**DEVELOPMENT REVIEW BOARD**  
**Action Sheet**

- 1. Project# 1006950**  
13DRB-70529 EPC APPROVED SDP  
FOR SUBDIVISION  
BOHANNAN HUSTON INC agent(s) for TPCB, LLC request(s) the above action(s) for all or a portion of Lot(s) A, **PLAT OF TRACT A, LAND OF SIERRA WEST, LLC** zoned R-1, located on WYOMING BETWEEN MOUNTAIN AND WEST BOUND I-40 containing approximately 1.13 acre(s). (J-20) **THE SITE DEVELOPMENT PLAN FOR SUBDIVISION WAS APPROVED.**

Project #: 1006950

Project Name: PLAT OF TRACT A, LAND OF SIERRA WEST, LLC

PLAT OF TRACT A LAND OF SIERRA WEST LLC

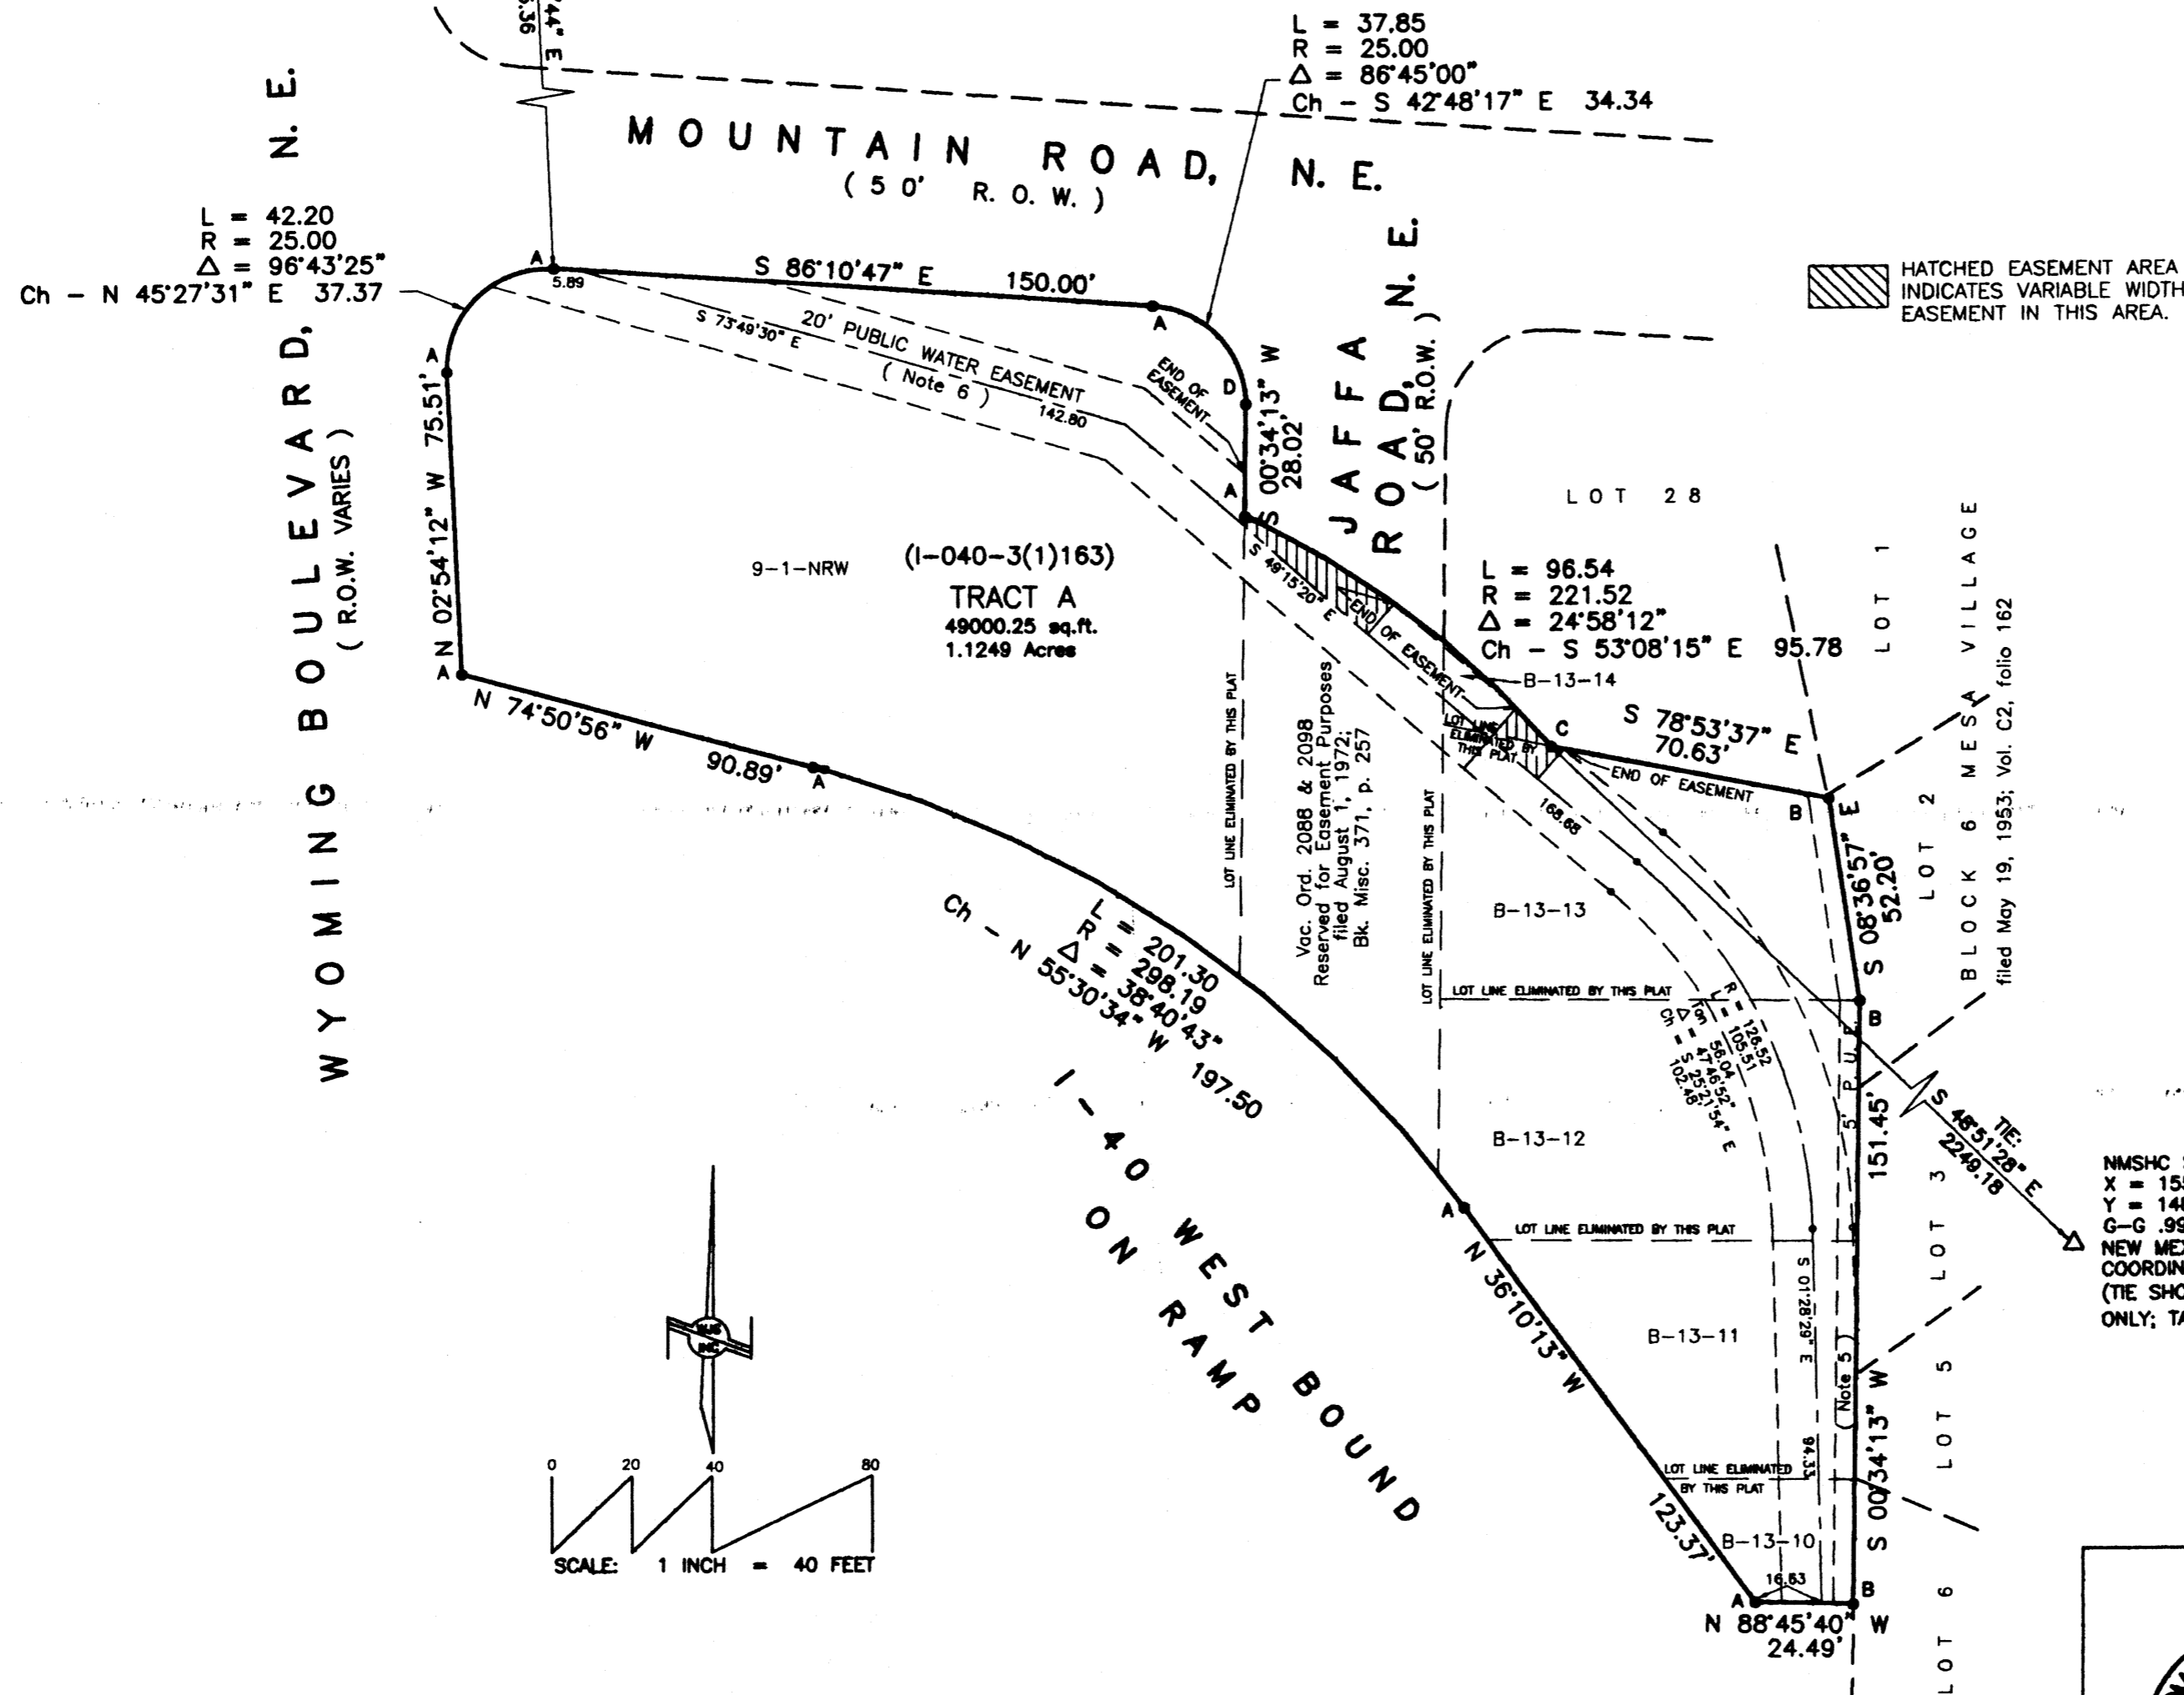
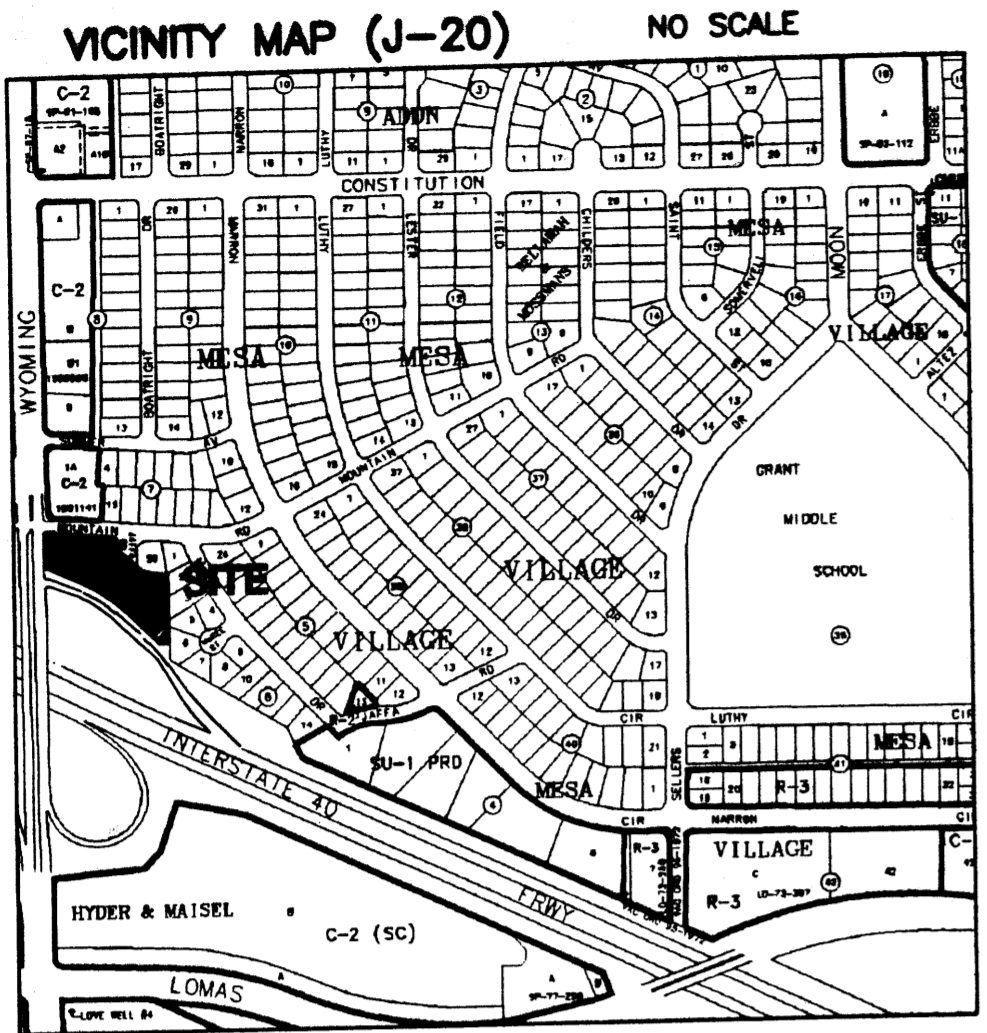
For future reference, please revise solar note to be specific to this type of request, i.e. replace the words "REQUESTED FINAL ACTION" with the word "THIS PLAT" at the beginning of the note.

EXISTING CONDITIONS

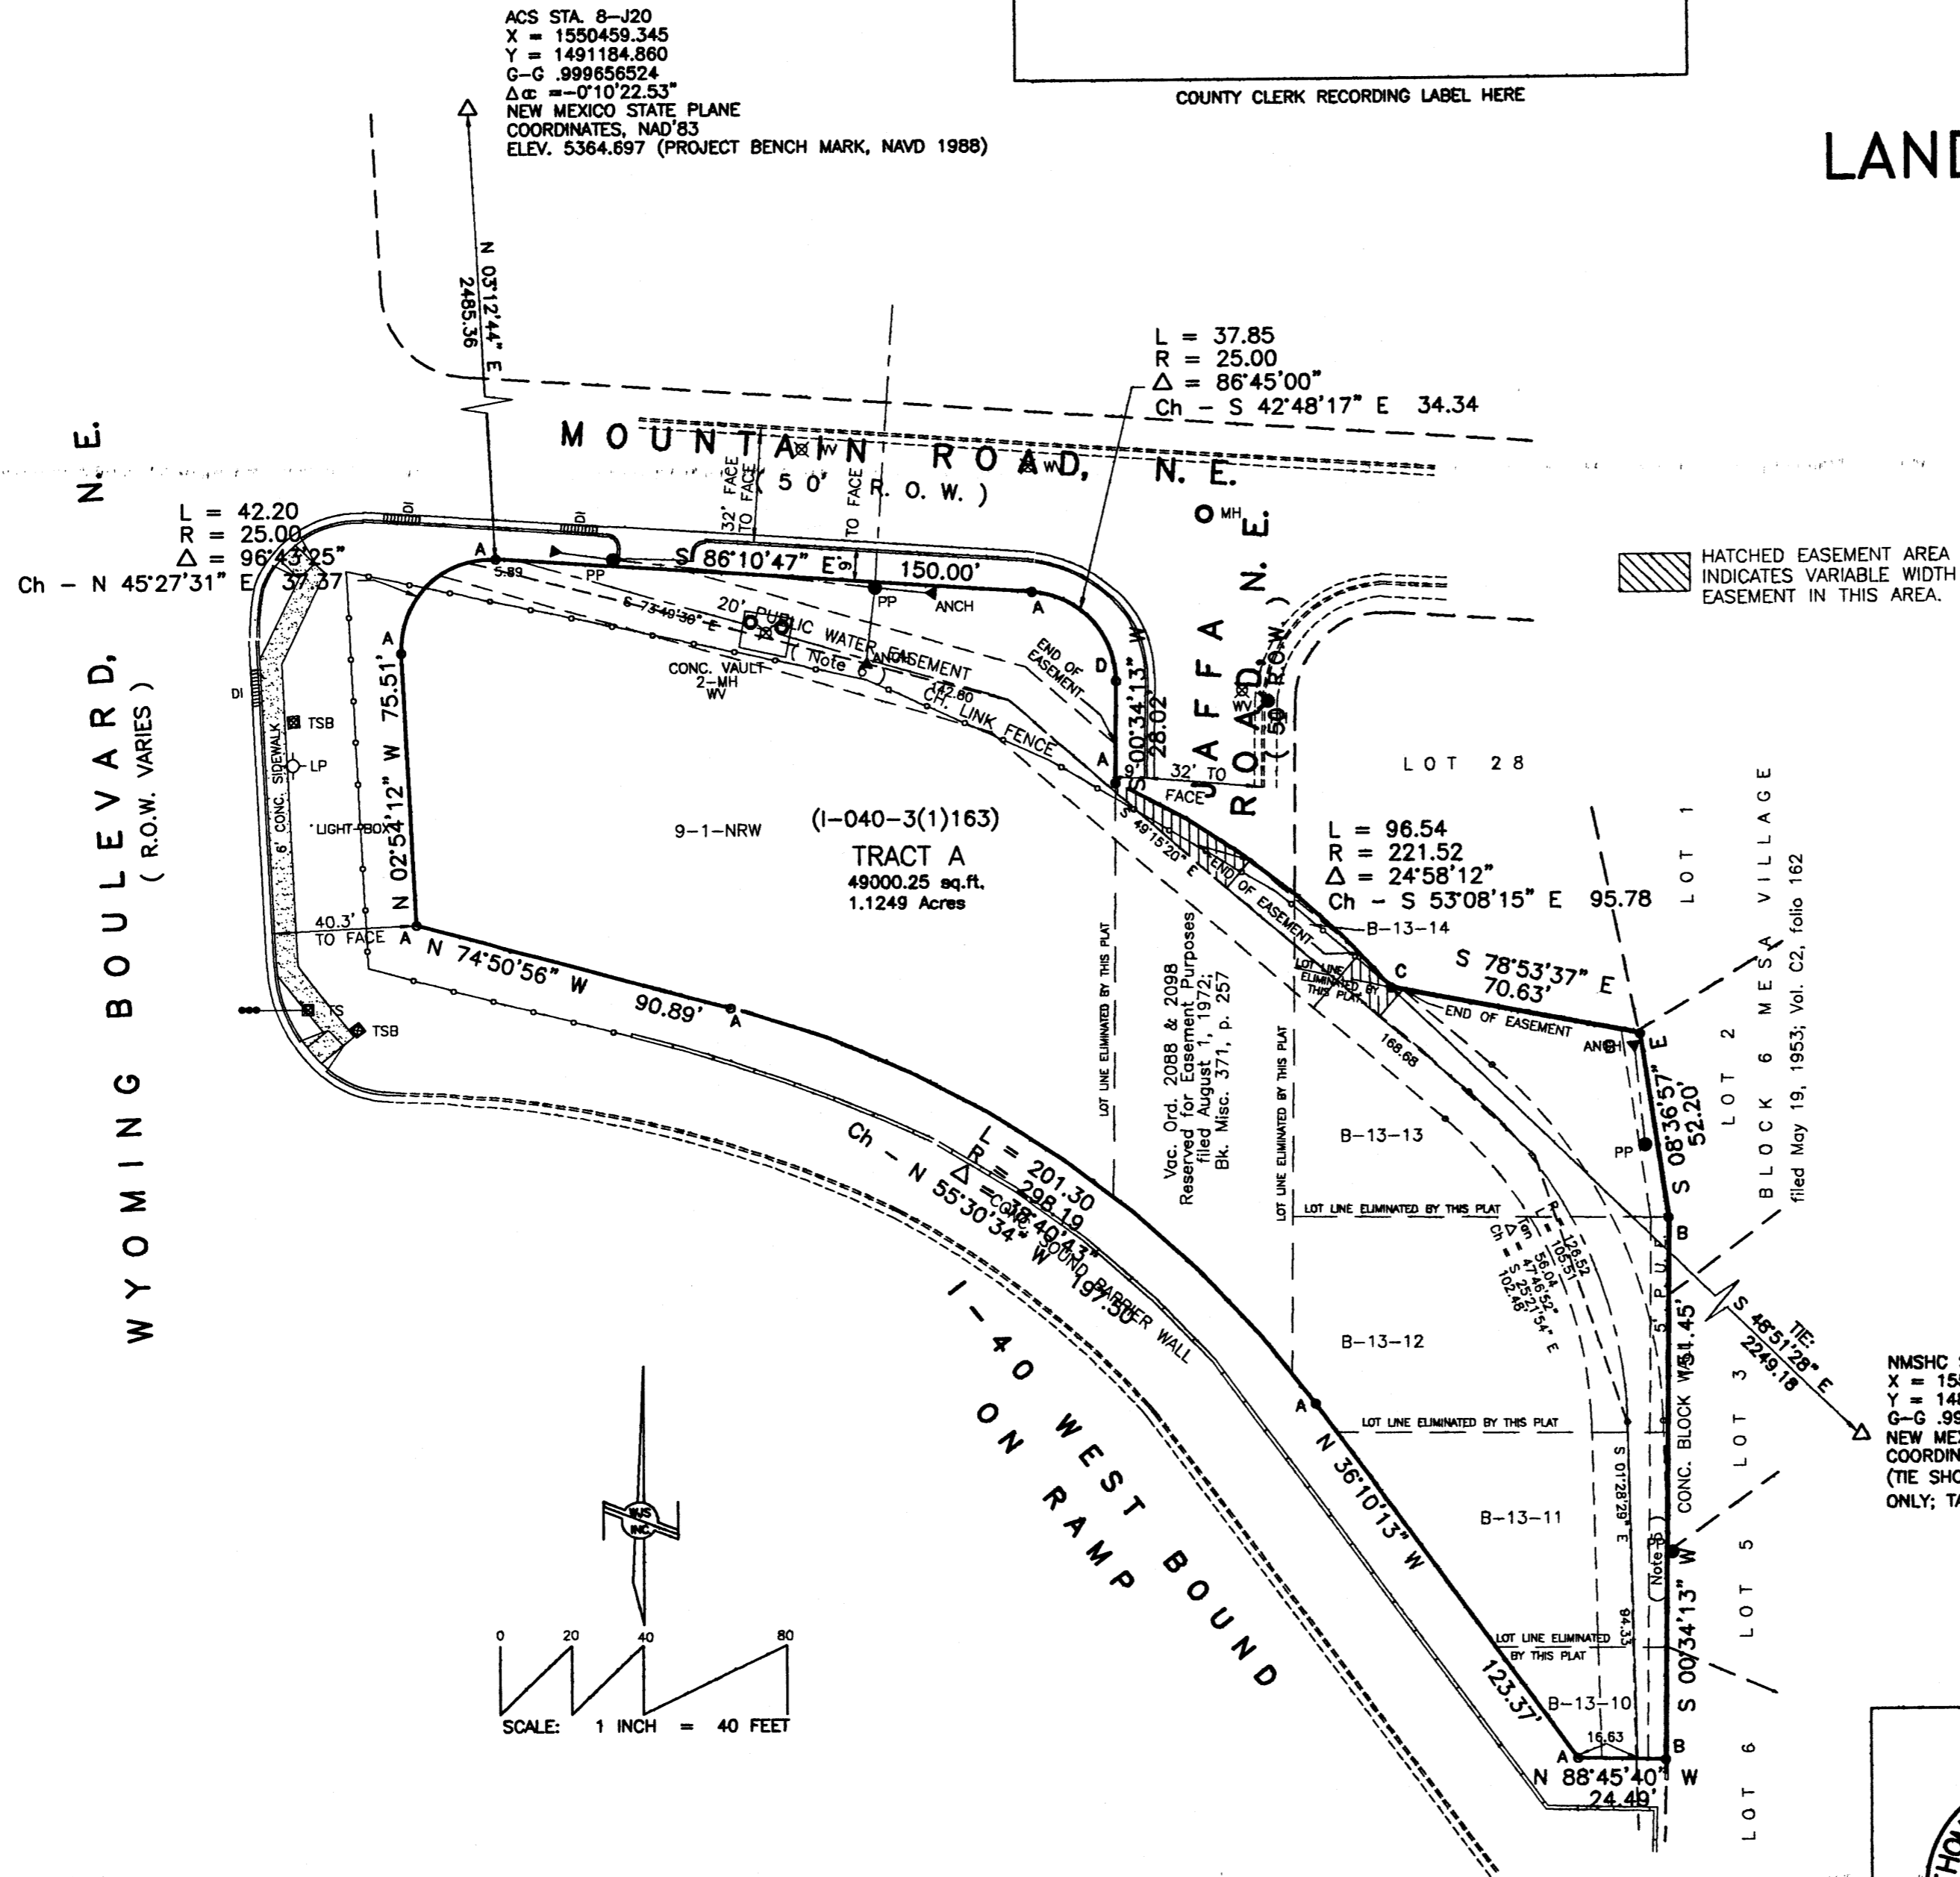
Exhibit does not define the layout of the site  
Has Jaffa Road been vacated? A vacation would need to take place prior to development
